Re.: SUB22-001 Lot Consolidation Application, Response to comments

This letter is in response to a comment letter dated January 18, 2023 and accompanies our re-submittal of Lot Consolidation Application on behalf of our client Xing Hua.

EXISTING CONDITIONS

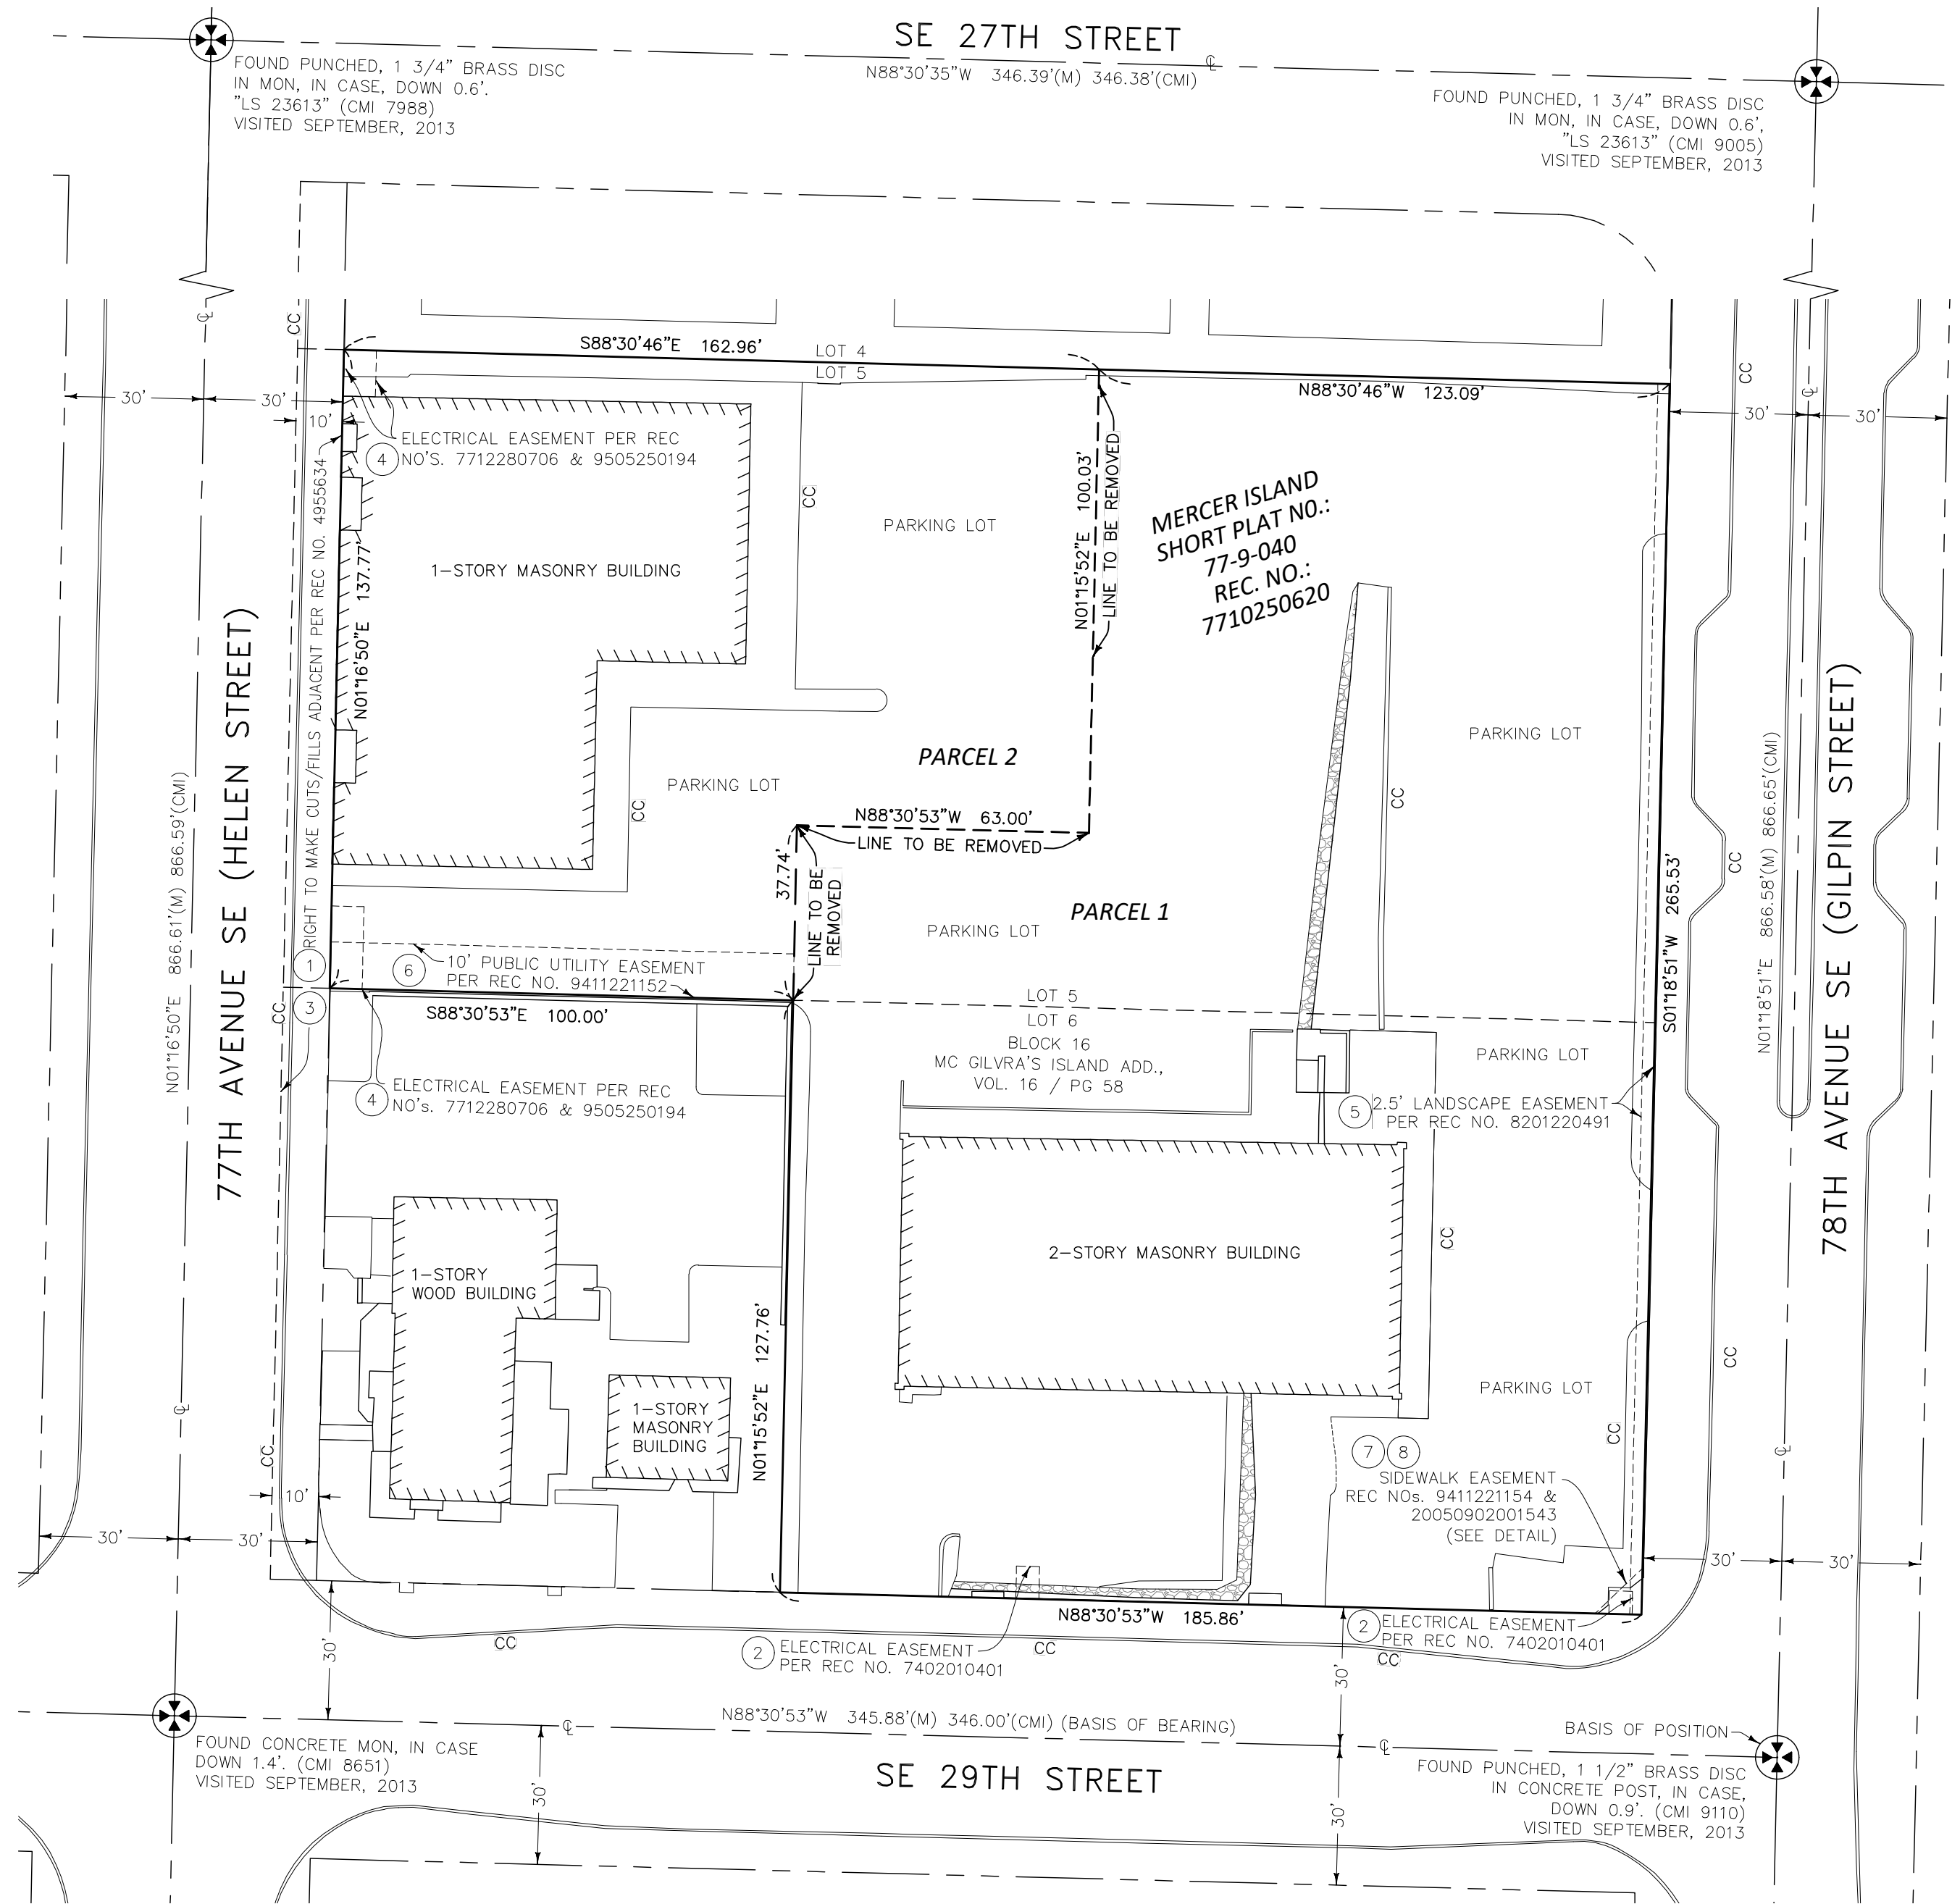
5. Please clarify whether the common parking area, as recorded under recording number 7710250324, will be extinguished.

- *Regarding easement rec. no.: 7710250324 for common parking area previously shown and in old title report, this easement has been terminated, Rec. No.: 20230321000044 (also being submitted via the Permit Submittal Portal)*

PROPOSED PARCEL

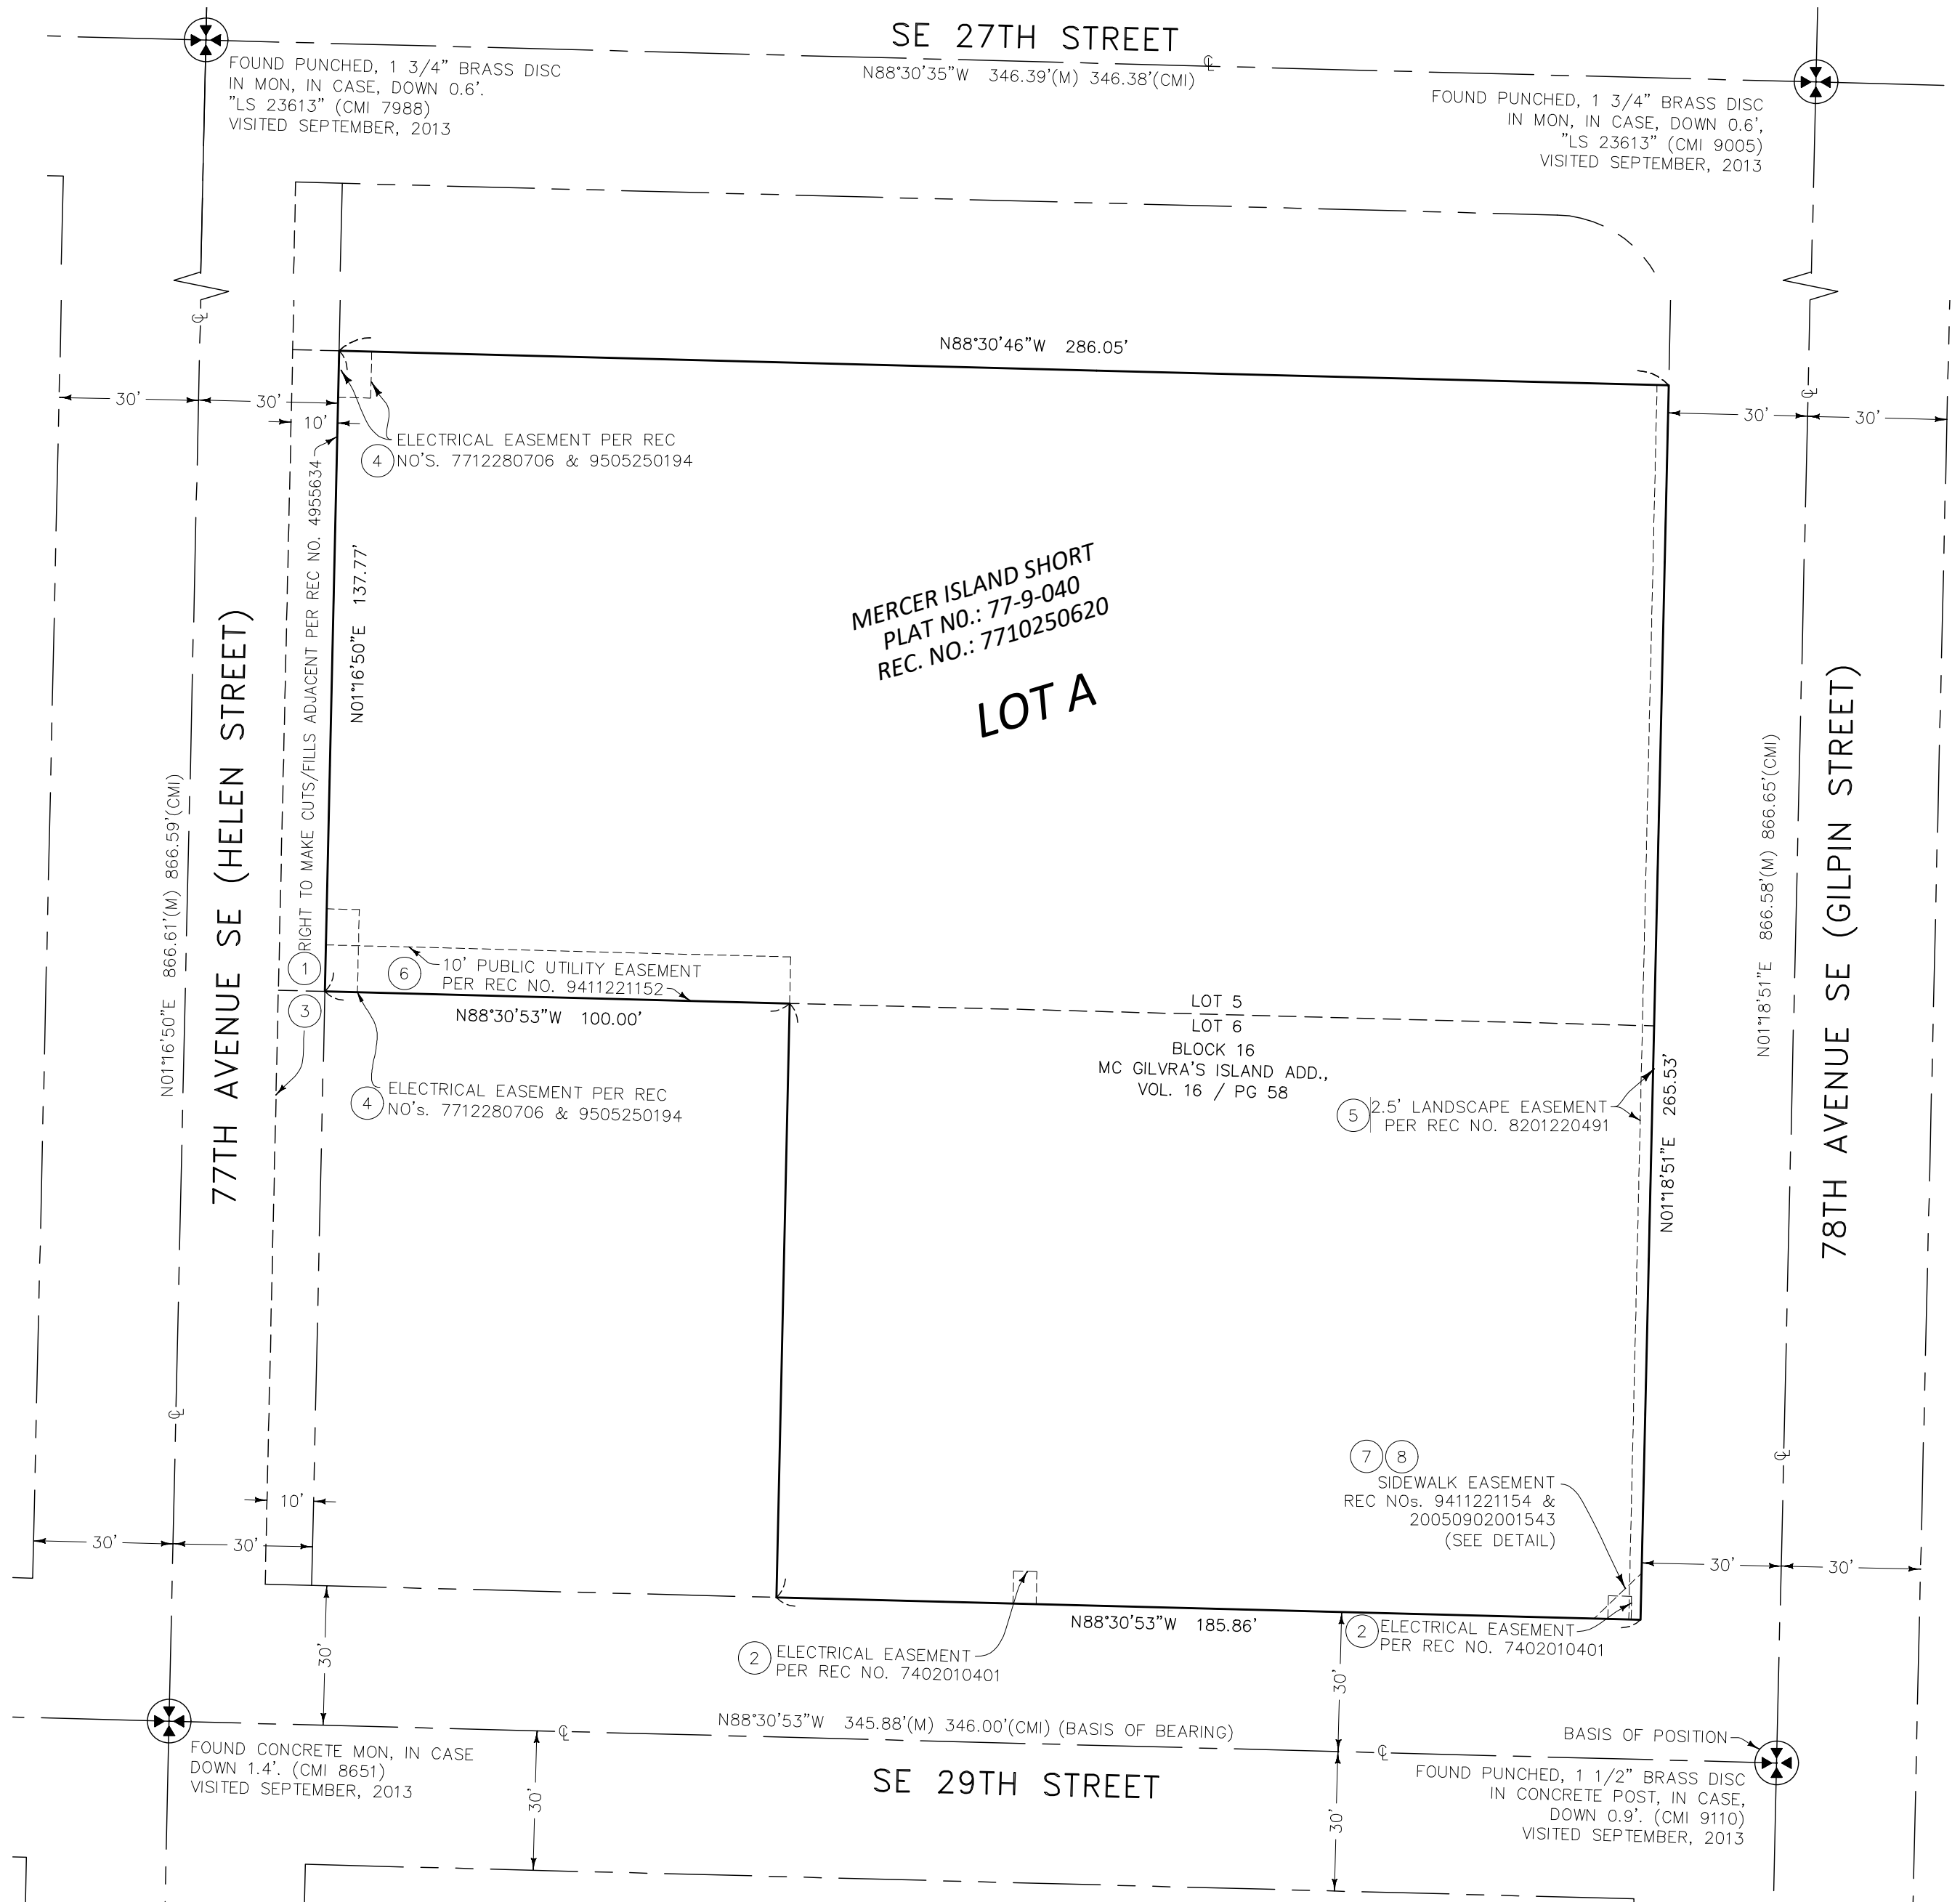
- *Lot Closure calculation by PLS is also being submitted via the Permit Submittal Portal*
- Civil Engineering:
  4. Please provide a plat map showing only the new lot lines, right-of-way bearings and distances, easements with limits, recording numbers, etc.

- *An additional sheet was created showing only new lot lines, easements and right of way lines.*
